Application for a non-material amendment following the grant of BR/135/13/ for moving Plot 7's rear garden entrance to the back of the carport & hipped roof to both carports (serving plot 5 & 7)

Land to the rear of No.6, Ockley Road, Bognor Regis, PO21 2HW

Planning Application – BR/239/17/NMA

With regards to the above application submitted on 18/08/2017 please find the attached drawing 02_Rev H_Site Plan, which is to replace the previous drawing 02 Rev G which was submitted with the application.

| Proposed Site Plan<br>& Landscape Plan |

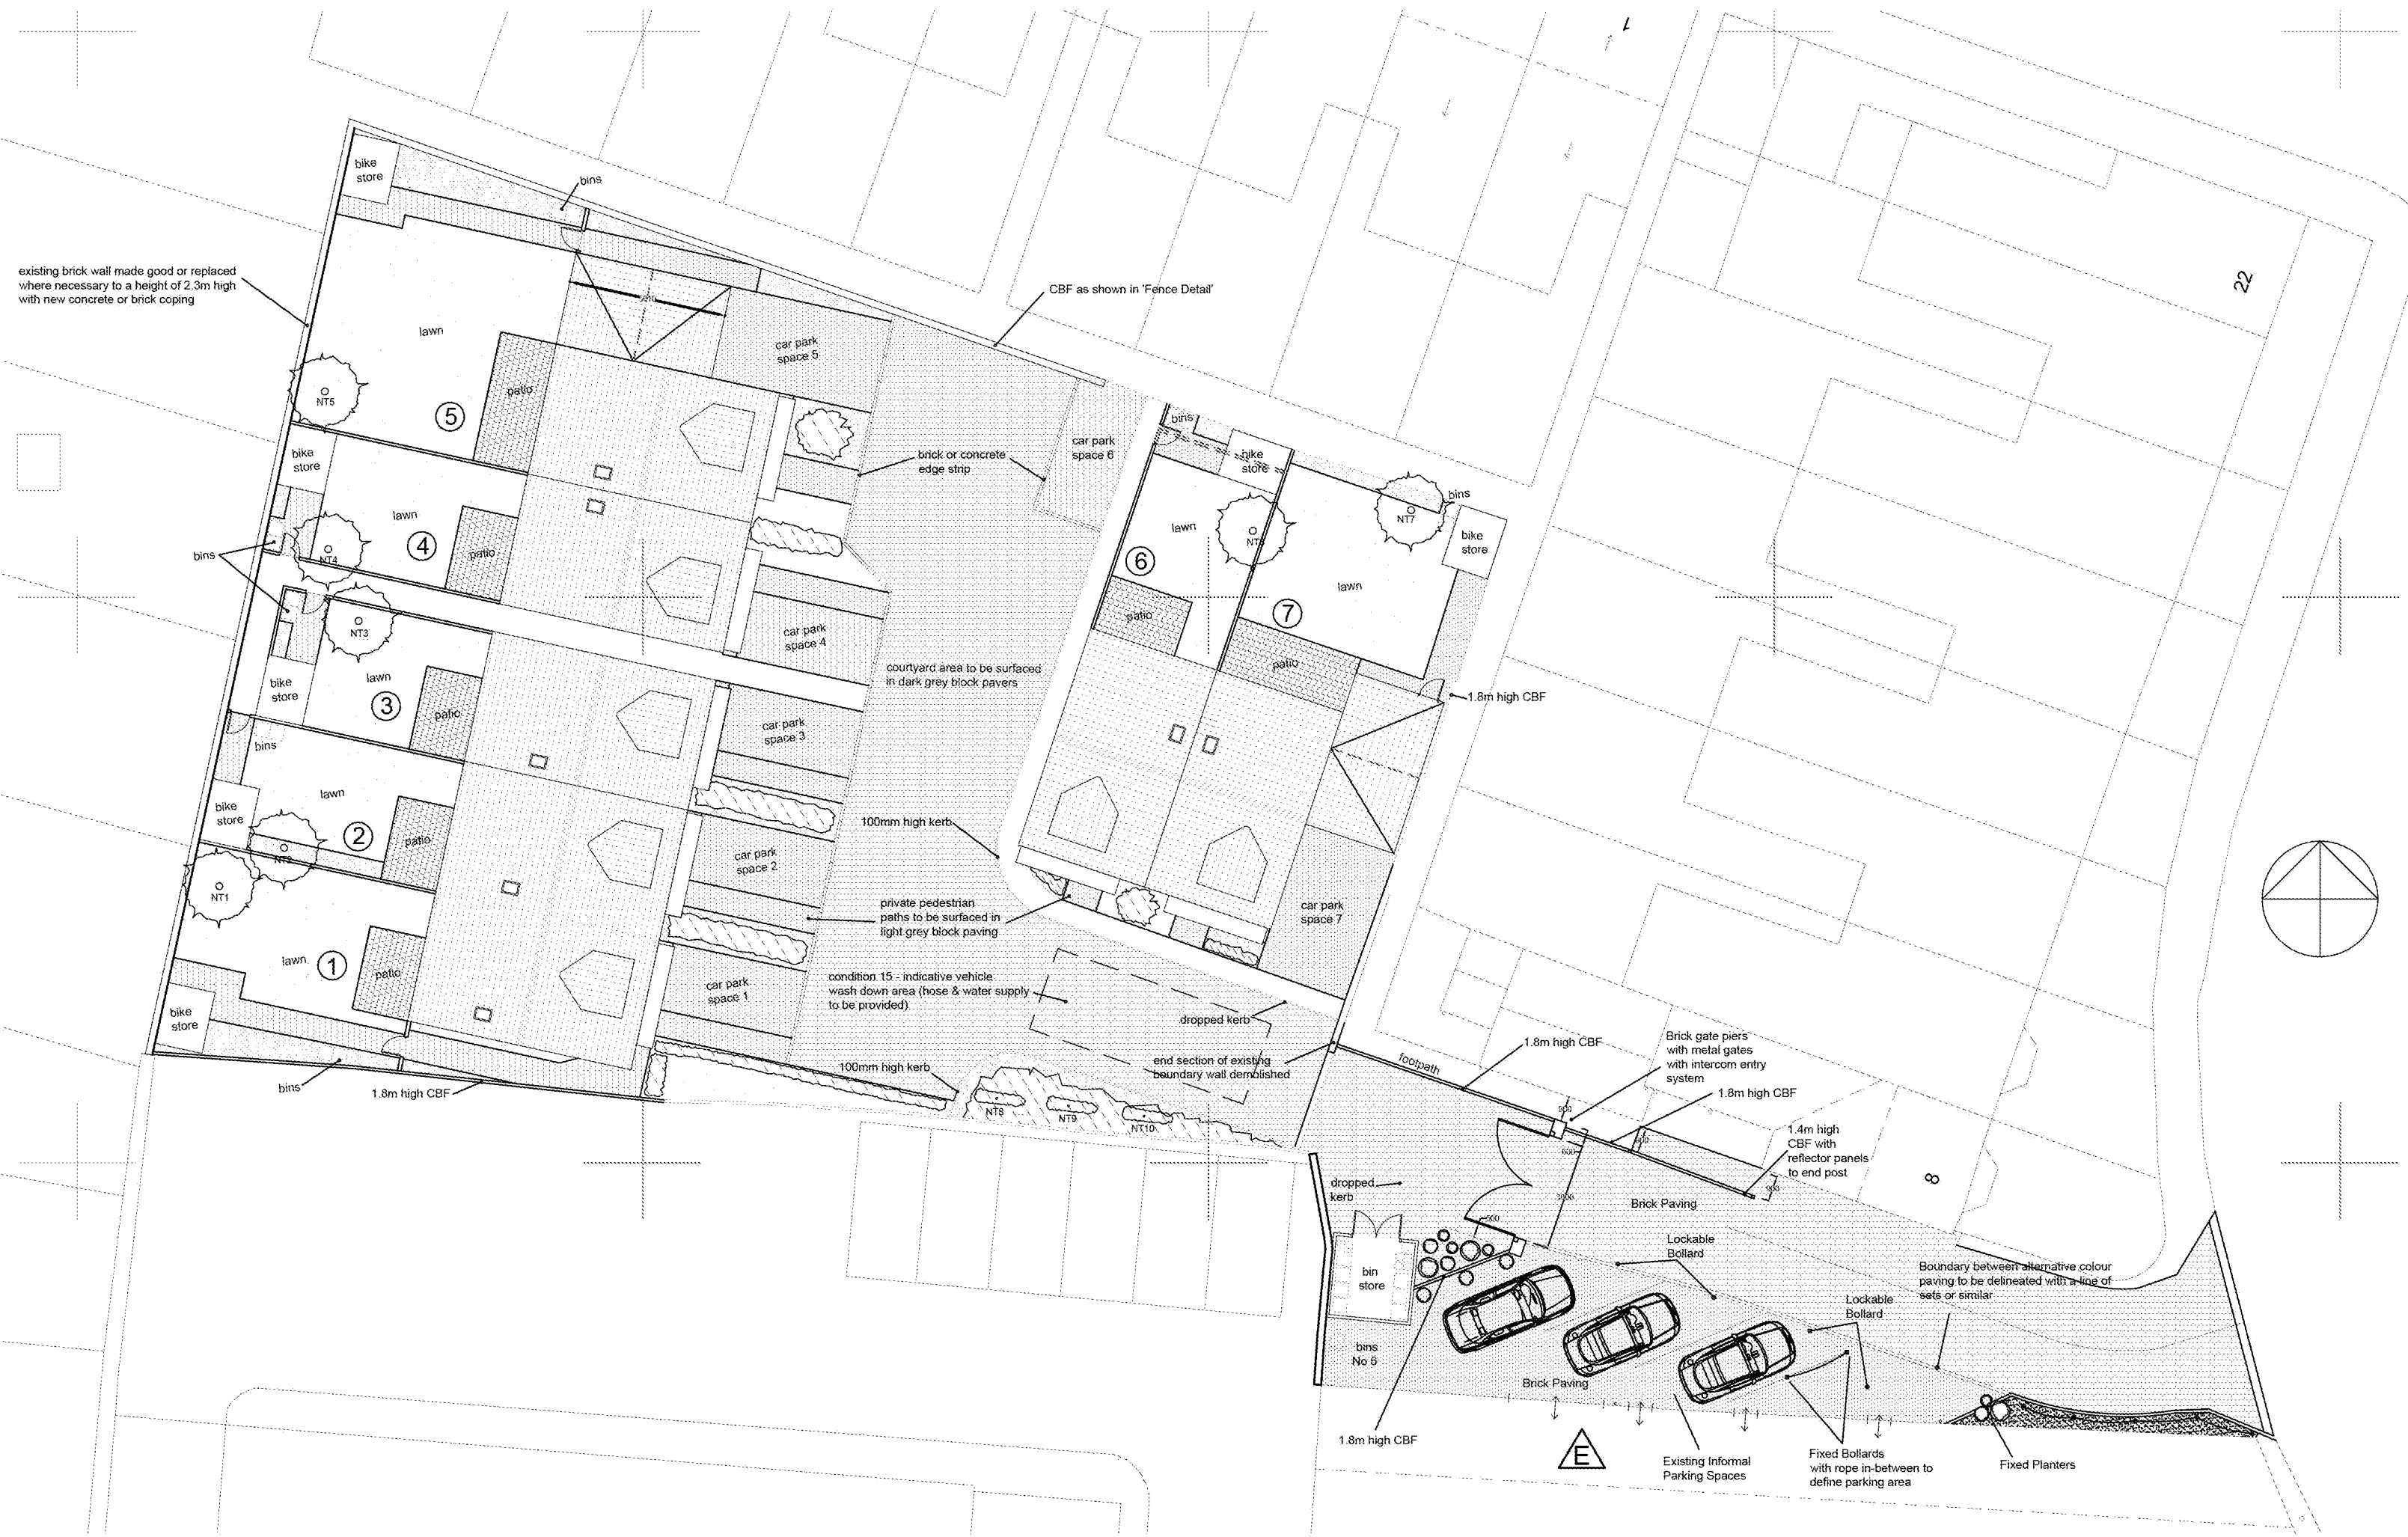
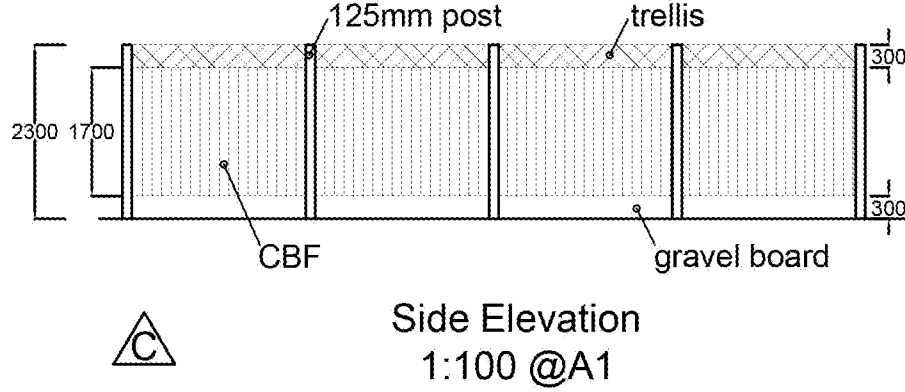
The changes to this revised drawing include the removal of the side pedestrian access gate (the pedestrians can use the main gates) and the addition of pillars either side of the electric gates to allow for more space behind the moving elements which is a safety requirement.
